| Application Ref: | 2025/0538 | | |  Ribble Valley Borough Council <hr/> www.ribblevalley.gov.uk |
| DELEGATED ITEM FILE REPORT: | | | | REFUSAL |

| Development Description: | Listed Building Consent: Insertion of 3 rooflights to southern roof slope. |
| Site Address/Location: | Barn at Talbot Hotel 5 Talbot Street Chipping PR3 2QE |

Photo 1:

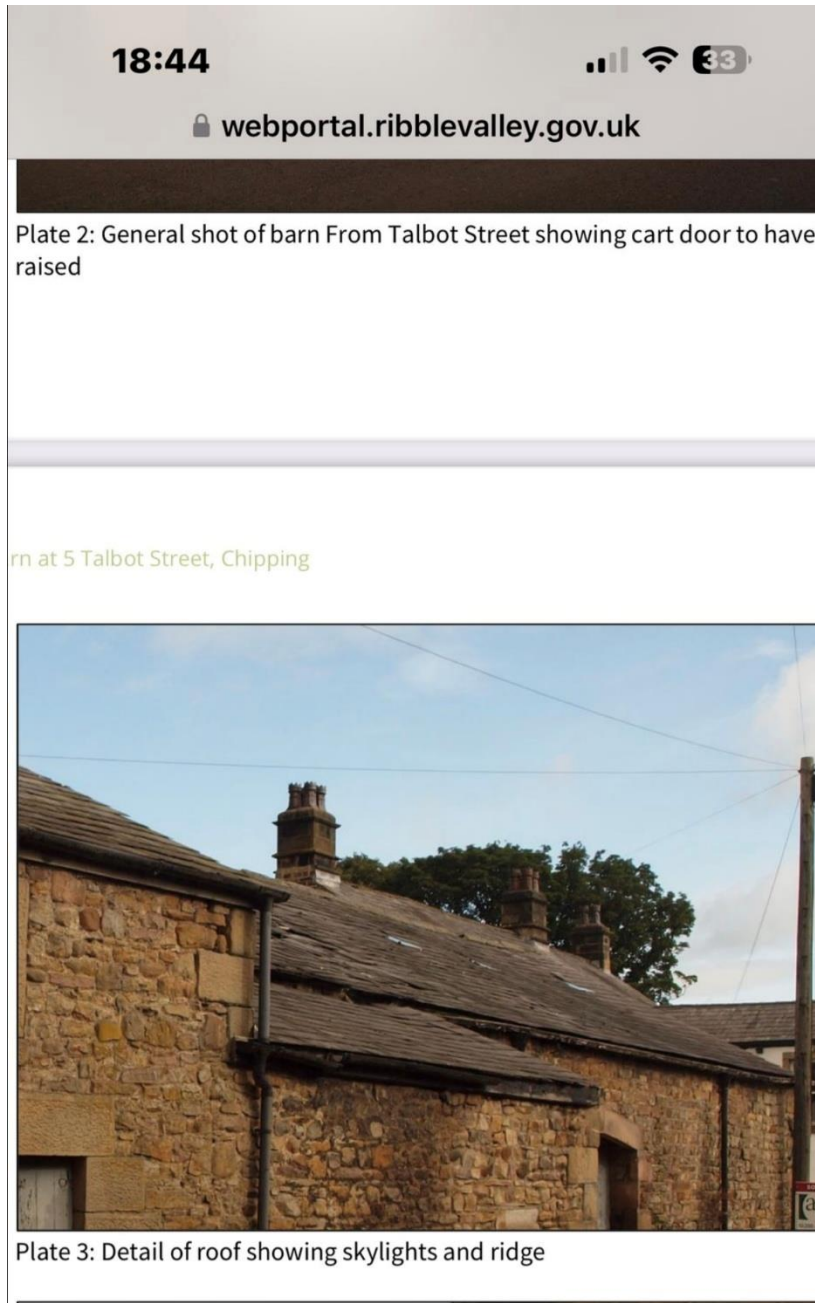
Photographic evidence shows three modest sized agricultural glass 'slates' or similar were present in the southern elevation. Limited information on how long they were in situ for has been provided. However, the majority of the historic fabric of the roof including these slates were removed and replaced as part of listed building consent 3/2024/0339 which sought consent to remove the existing trusses and re-roof the existing roof with replacement slates. This work has been completed.

Therefore, this proposal is not a consideration of replacing existing rooflights but results in the insertion of three new rooflights on this prominent roof slope which is considered to be unduly harmful to the building's character and result in a less than substantial (low level) of harm to the heritage asset.

Photographic evidence shows three modest sized agricultural glass ‘slates’ or similar were present in the southern elevation. Limited information on how long they were in situ for has been provided. However, the majority of the historic fabric of the roof including the original agricultural rooflights was removed the majority of the historic fabric of the roof including these slates were removed and replaced as part of listed building consent 3/2024/0339 which sought consent to remove the existing trusses and re-roof the existing roof with replacement slates. This work has been completed.

Therefore, this proposal is not a consideration of replacing existing rooflights but results in the insertion of three new rooflights on this prominent roof slope which is considered to be unduly harmful to the building’s character and result in a less than substantial (low level) of harm to the heritage asset.
